WEST YORKSHIRE POLICE

To: Kate Mansell Kirklees Council Planning Services Civic Centre 1, High Street, Huddersfield, HD1 2NF	Ref: 2020/92546 Date: 3 rd September 2020
---	---

**Site Location: Land off Blackmoorfoot Road and Felks Street, Crosland Moor,
Huddersfield, HD4 7AD**

Application Type: Outline - 770 dwellings including 70 care apartments and doctors surgery

Org No	Suitability	Revision
PL1713-PLA-XX-XX-DR-U-0010	S1	P03

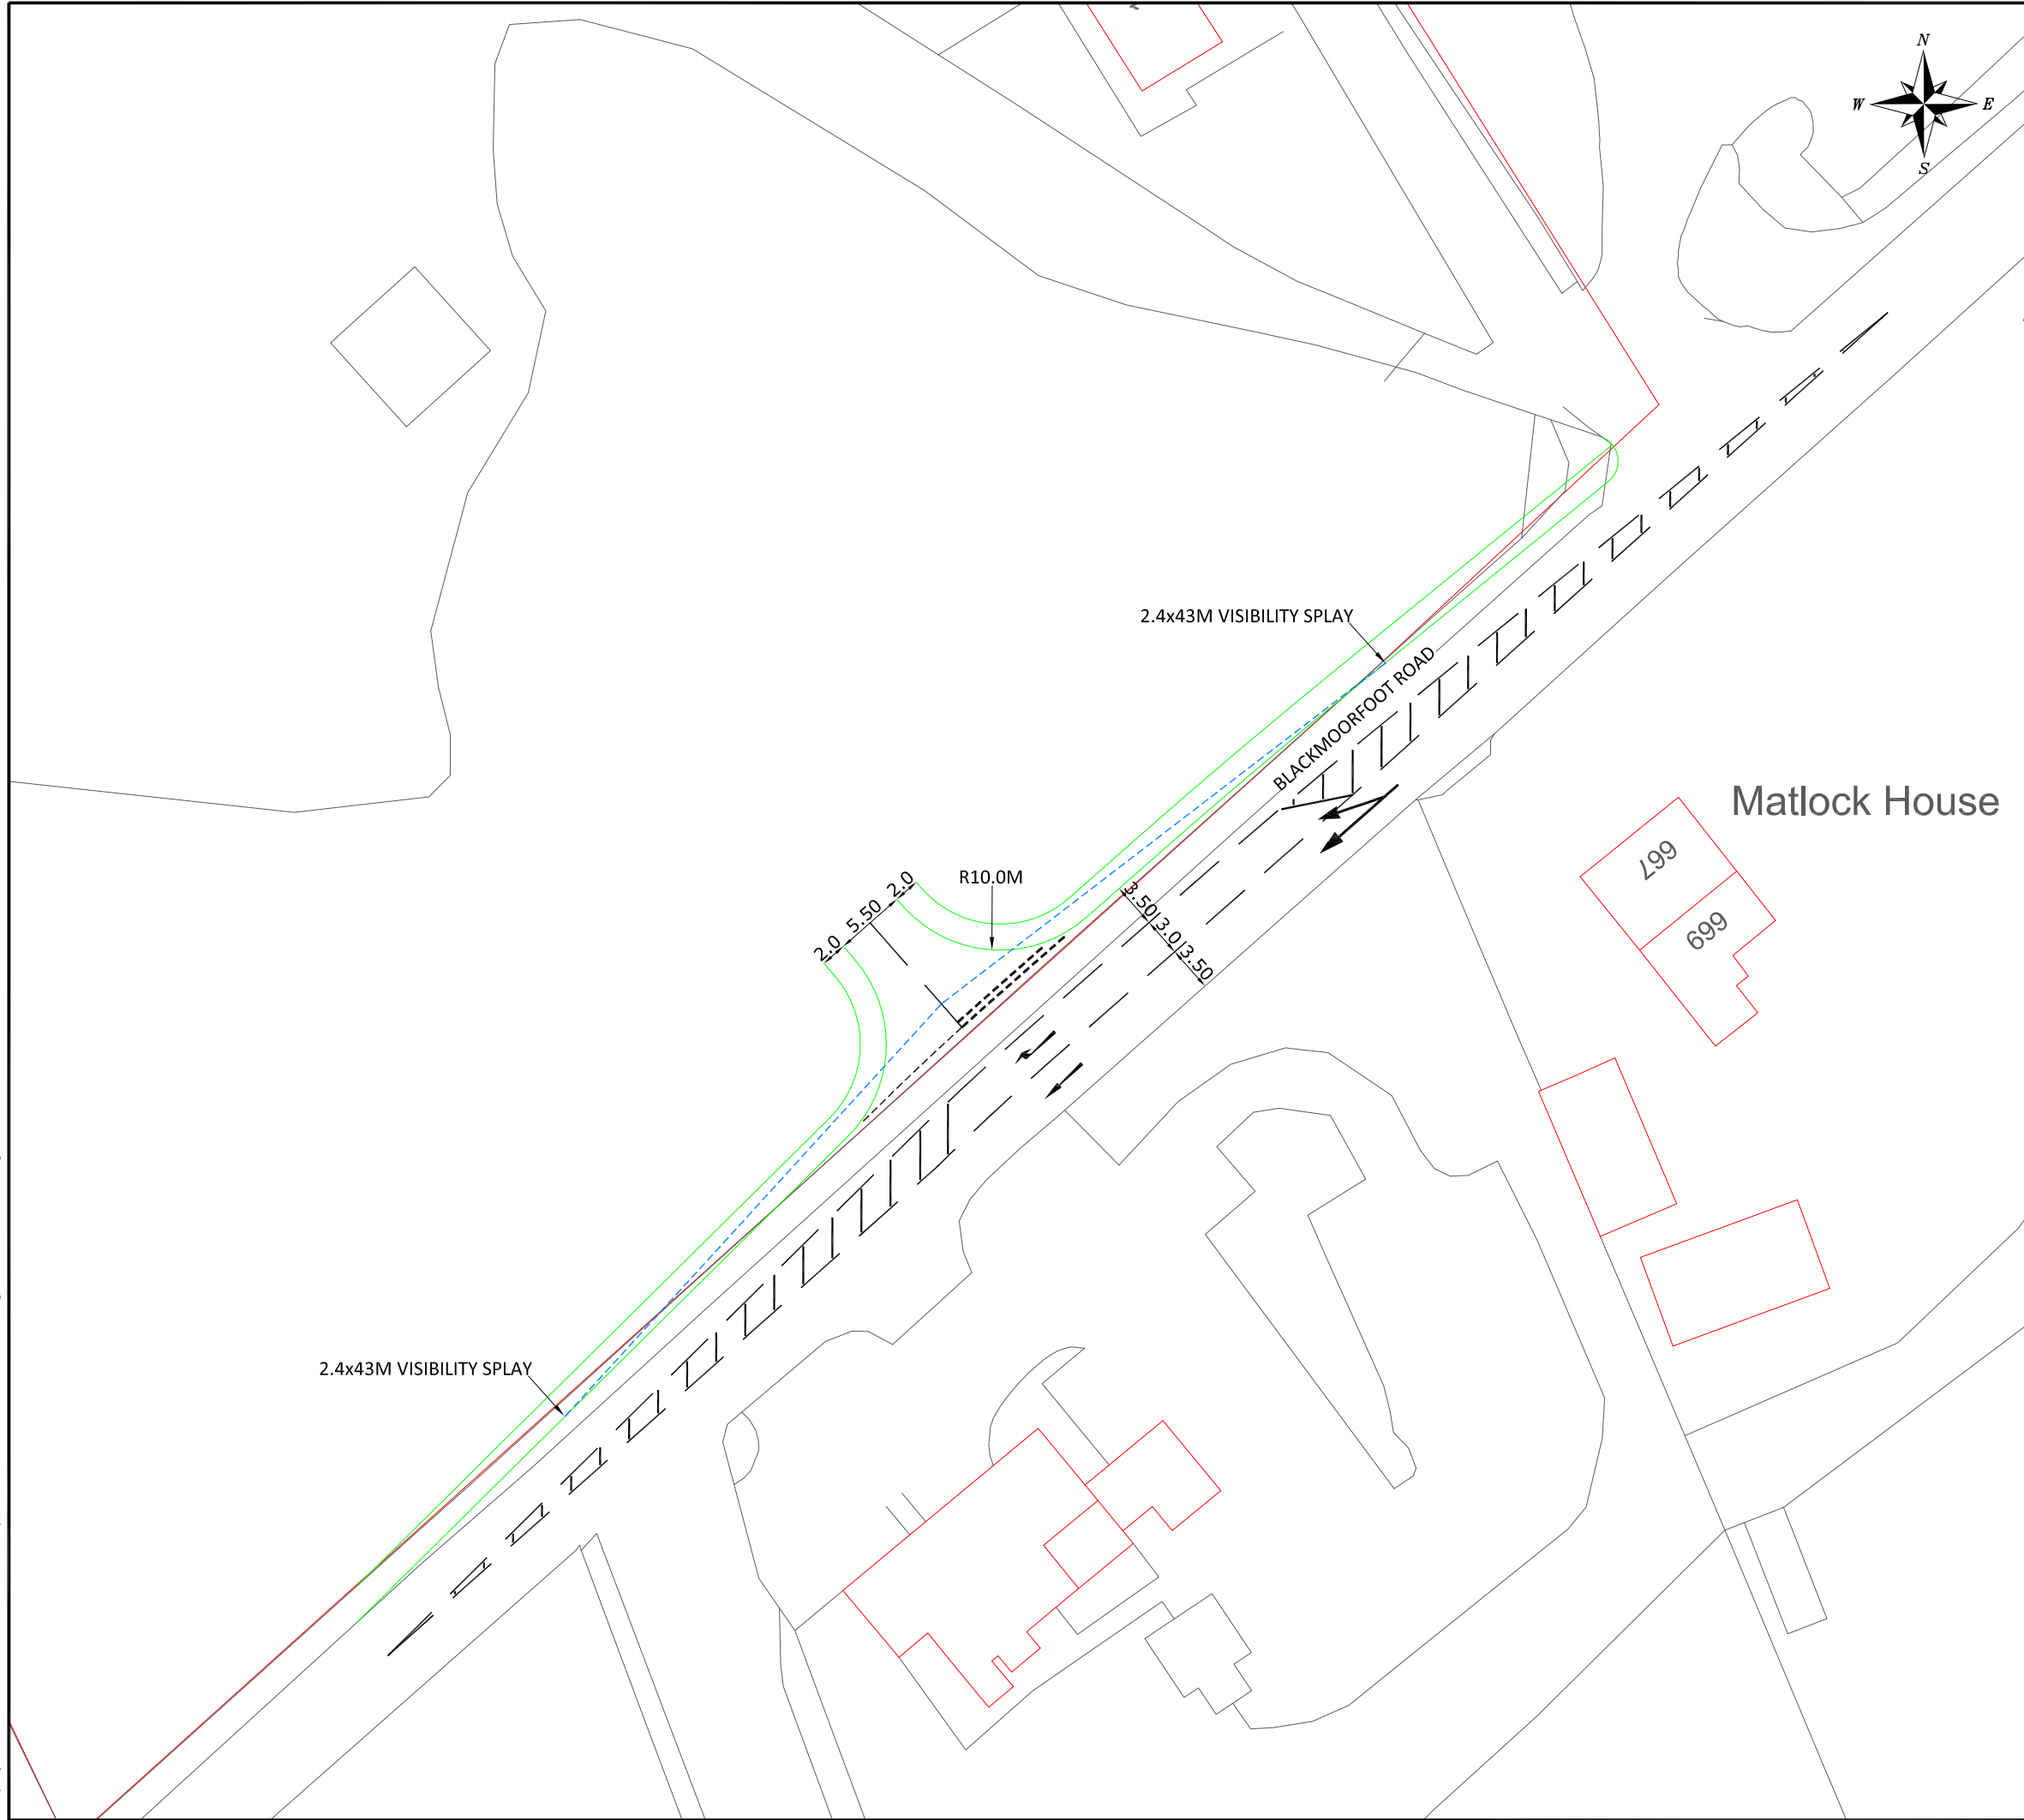
Referring to site plan drawing number **PL1713-PLA-XX-XX-DR-U-0010 rev P04 dated 31/07/2020.**

- **Limitation of permeability** - The security of the development must not be compromised by having excessive, unnecessary permeability, for instance giving unauthorised access to side and rear boundaries of dwellings, or by providing needless segregated footpaths.

- **Site layout** – It is encouraging to see the applicants have placed the fronts of the properties towards the street with rear gardens backing onto each other. This is recommended to reduce rear access burglary.

- **Site and property boundaries** – The applicant is requested to provide detailed boundary treatment plans in line with the below advice.

- **Doctors Surgery** – Detailed drawings for the Doctors Surgery will be required to assess the security of the premises due to such buildings being a target for offenders.
- **Care Apartments** – The applicants are encouraged to contact the DOCO directly to discuss security requirements for these properties.
- **Local Centre facility** – This kind of site facility can attract unwanted crime and anti-social behaviour if the design is not well thought out. The DOCO will be in a position to assist the applicants with advice for the layout of this facility and any proposed street furniture / seating etc.
